DRB CASE ACTION LOG (SITE PLAN B.P.)

DRB Application No.: 05DRB-01213 (SBP)
Project Name: ALAMEDA BUSINESS PARK
Agent: Bohannan Huston Inc

DRB CASE NO/PROJECT NO: 1004343

Site Plan for BP

City Project No. _____ Zone Map No. C-16-Z Sheet 1 Of 6

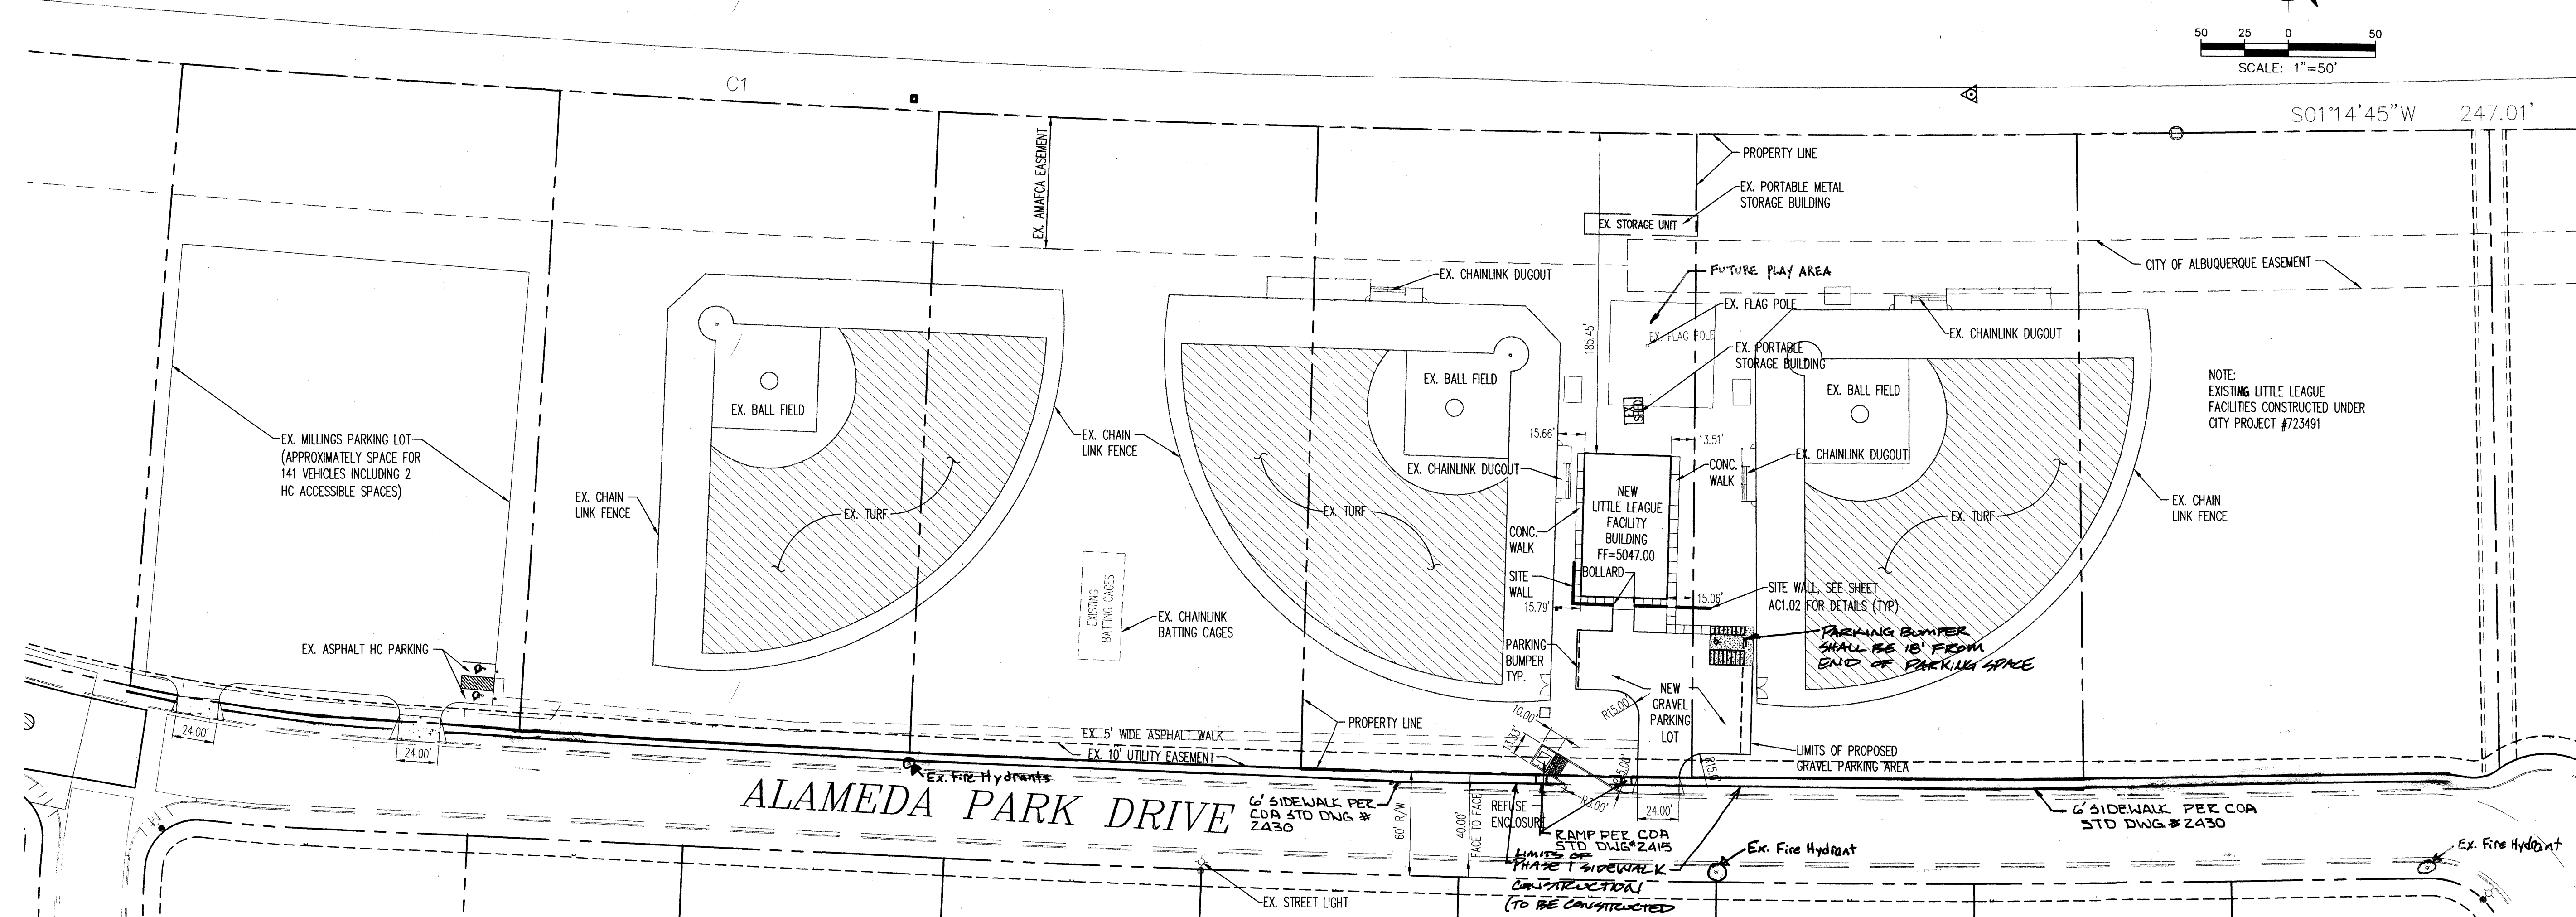
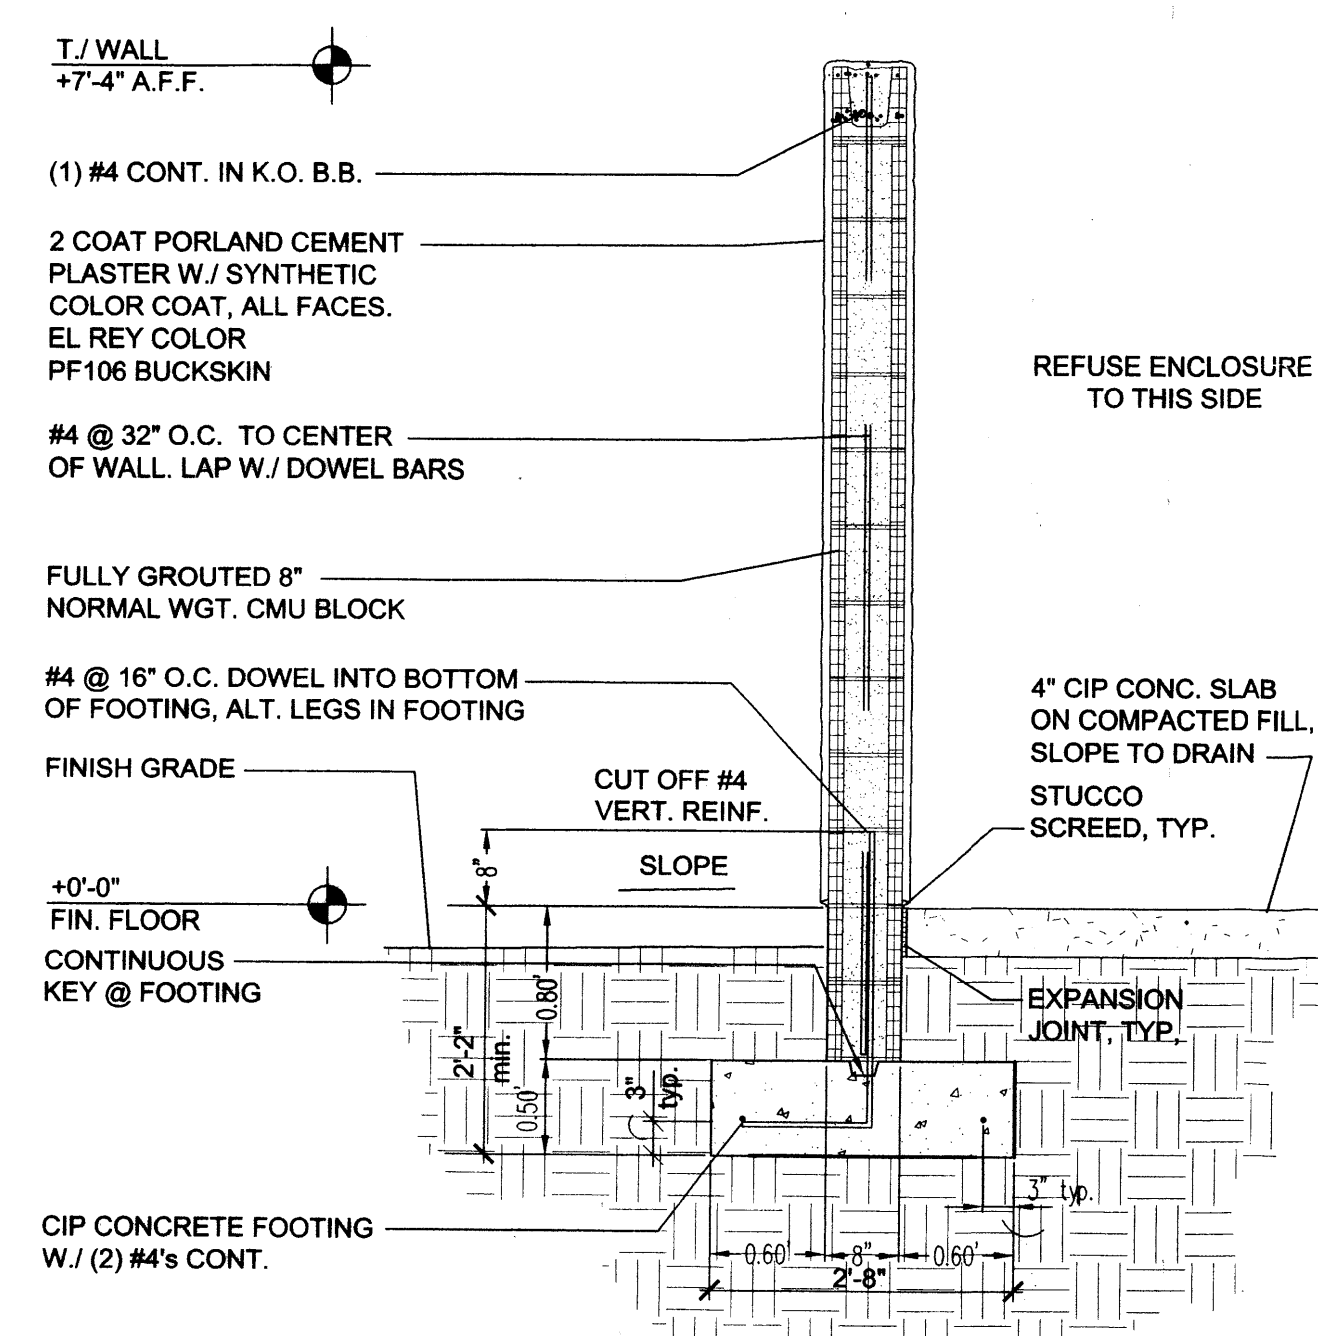
- TRANSPORTATION: sidewalk dimensions + detail ok [signature]
3 copies
-
-
-
-
- UTILITIES:
-
-
-
-
- CITY ENGINEER / AMAFCA:
-
-
-
-
- PARKS / CIP:
-
-
-
- PLANNING (Last to sign): 3 copies
-
-
-

BOHANNAN HUSTON INC. agent(s) for CITY OF ALBUQUERQUE request(s) the above action(s) for all or a portion of Lot(s) 22-27, **ALAMEDA BUSINESS PARK**, zoned SU-2 IP-EP, located on EDITH BLVD NW, between ALAMEDA PARK DR NW and the AMAFCA DIVERSION CHANNEL containing approximately 12 acre(s). [REF: DRB-98-223] [Deferred from 8/3/05 & 8/10/05 & INDEF DEFERRED ON 9/7/05] (C-16) **SITE PLAN FOR BUILDING PERMIT WAS APPROVED WITH FINAL SIGN OFF DELEGATED TO TRANSPORTATION DEVELOPMENT FOR SIDEWALK DIMENSIONING AND SIDEWALK DETAIL AND 3 COPIES OF THE SITE PLAN.**
